From: Jacqui B
To: [Robin Proebsting](mailto:Robin.Proebsting)
Cc: jerm721@aol.com
Subject: Comments on the proposed development at 2825 WMW
Date: Wednesday, May 8, 2019 4:09:28 PM

As a property owner adjacent to this proposed development, I have a few questions/concerns regarding the project:

PRELIMINARY TREE RETENTION AND REPLACEMENT PLAN
2825 W MERCER WAY
PRELIMINARY PLAT
 PARCEL #2174502425
 CITY OF MERCER ISLAND WASHINGTON

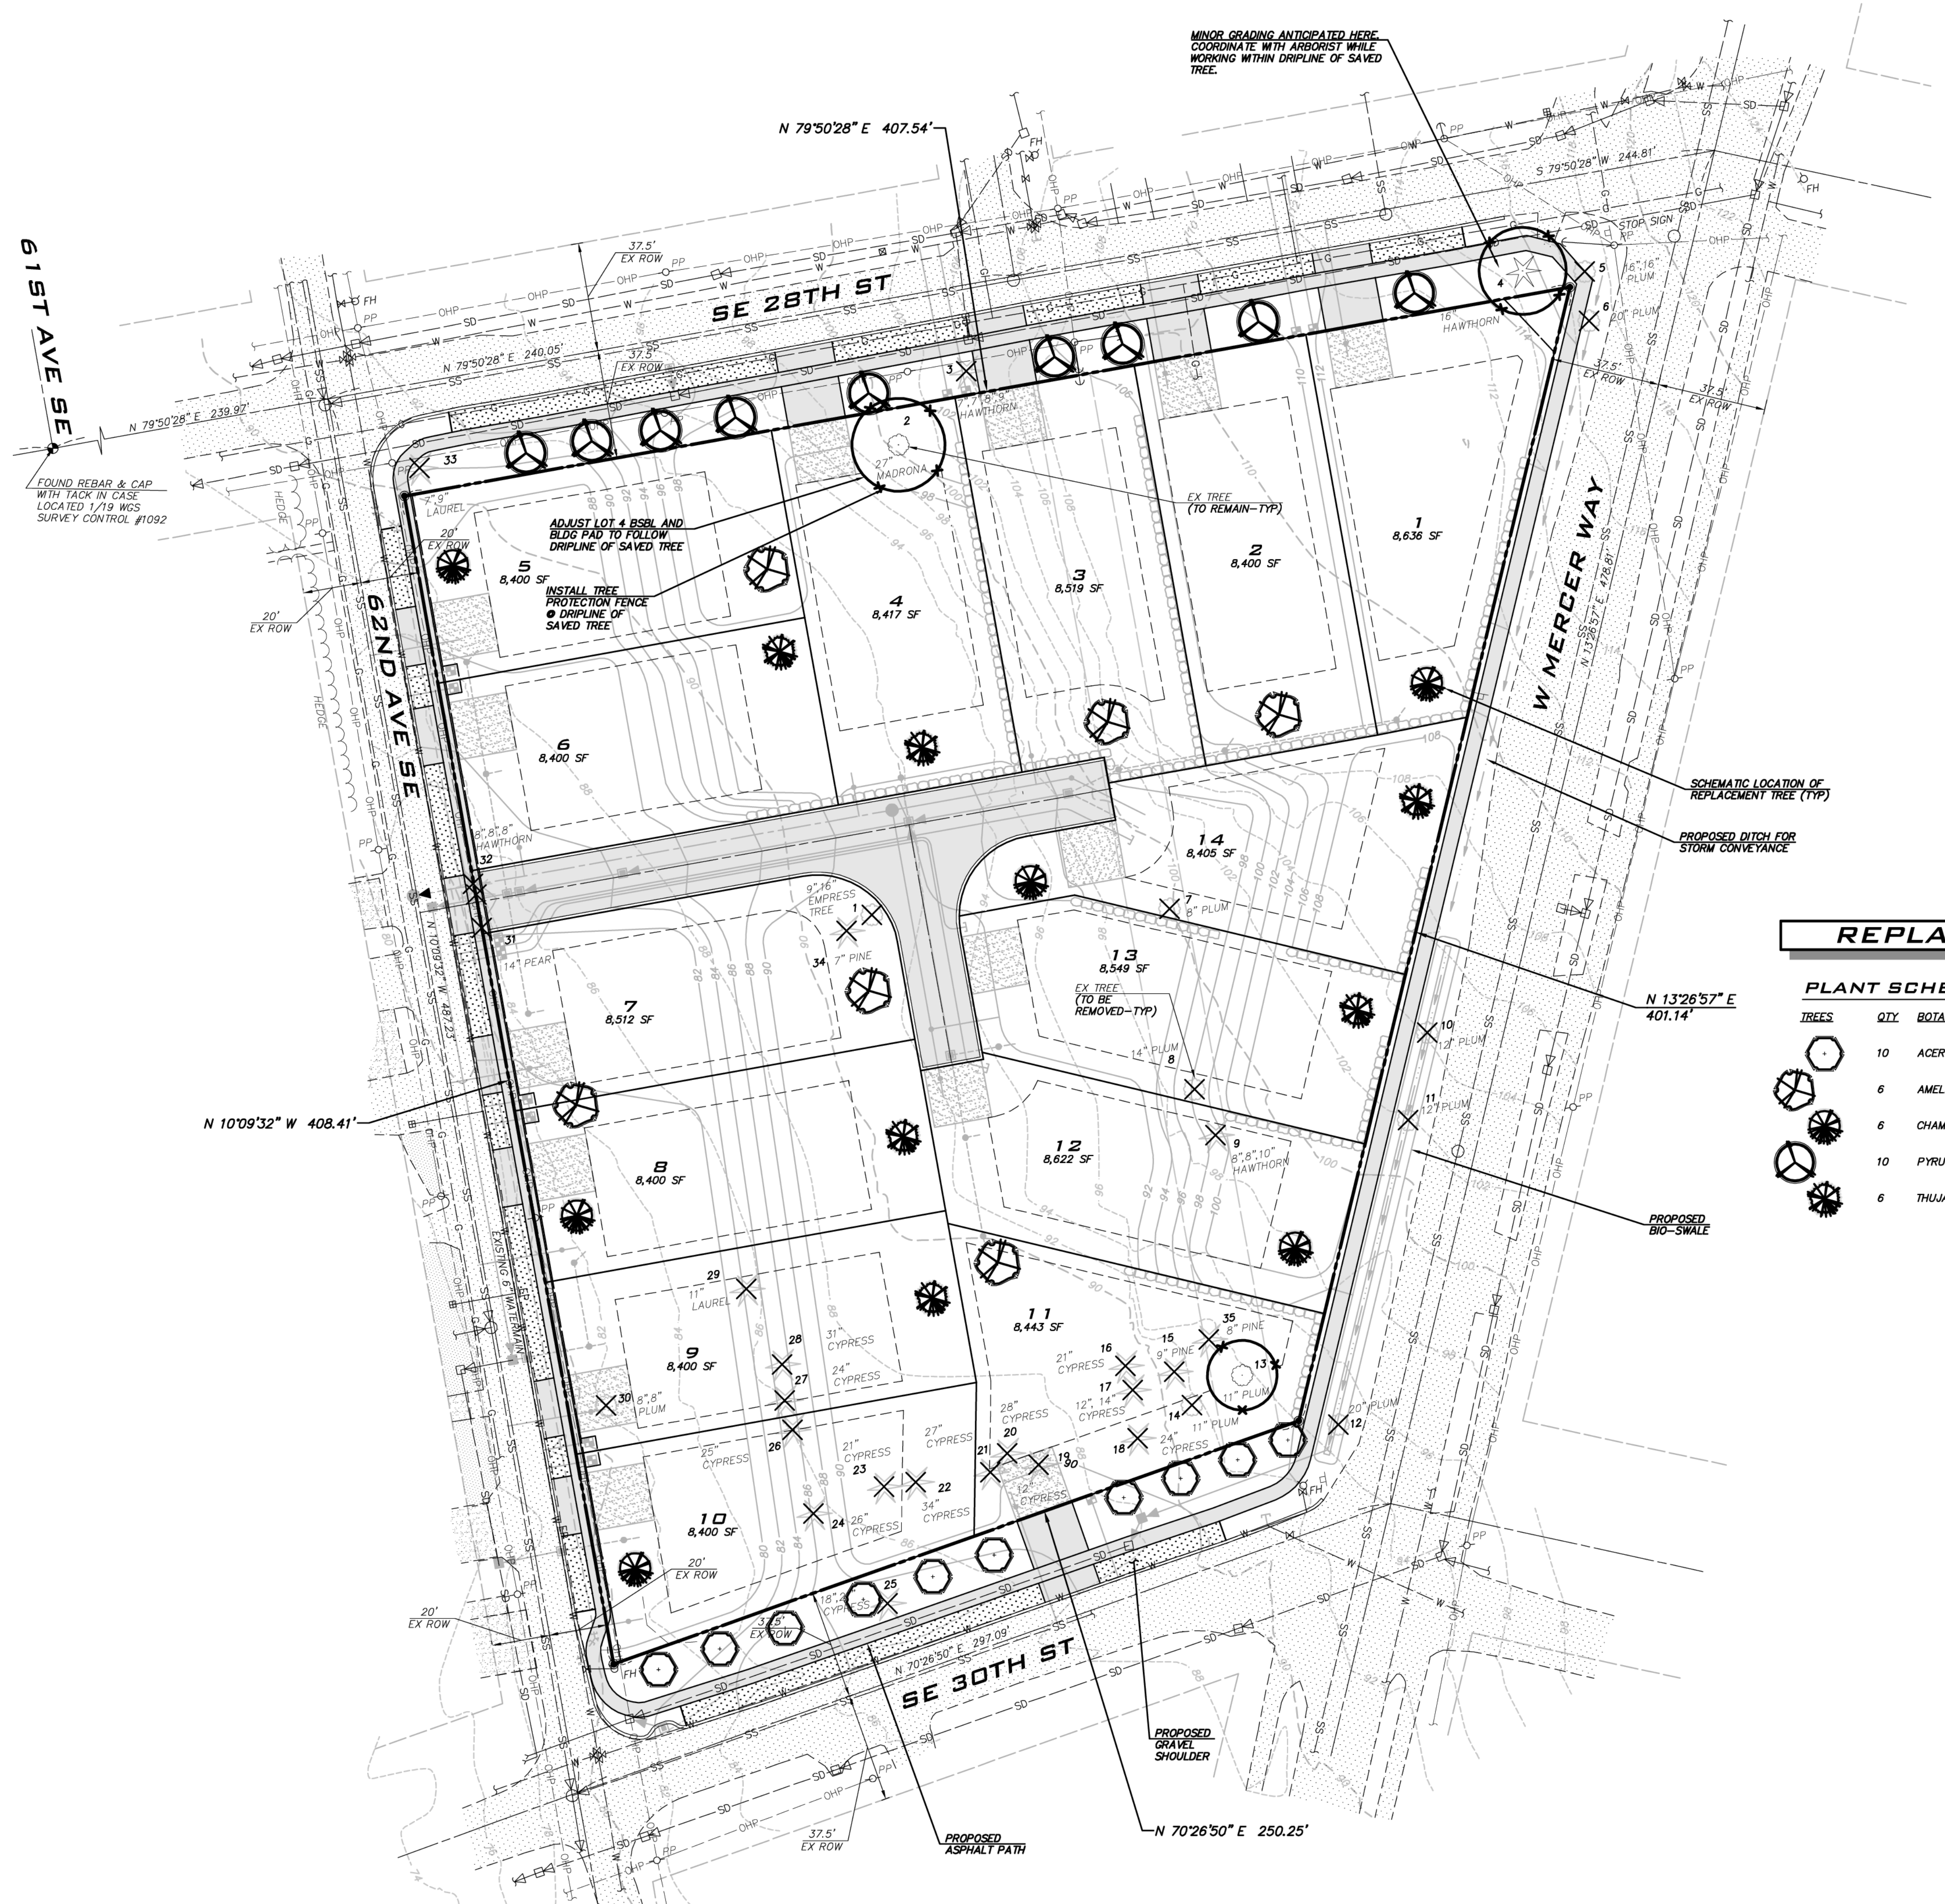
1. How will the project replace the vegetation slated for removal? I have concerns over the number of trees that will be removed, identified in the arborist report. Particularly alarming is the desire to remove an "exceptional" tree that the City has requested be retained.
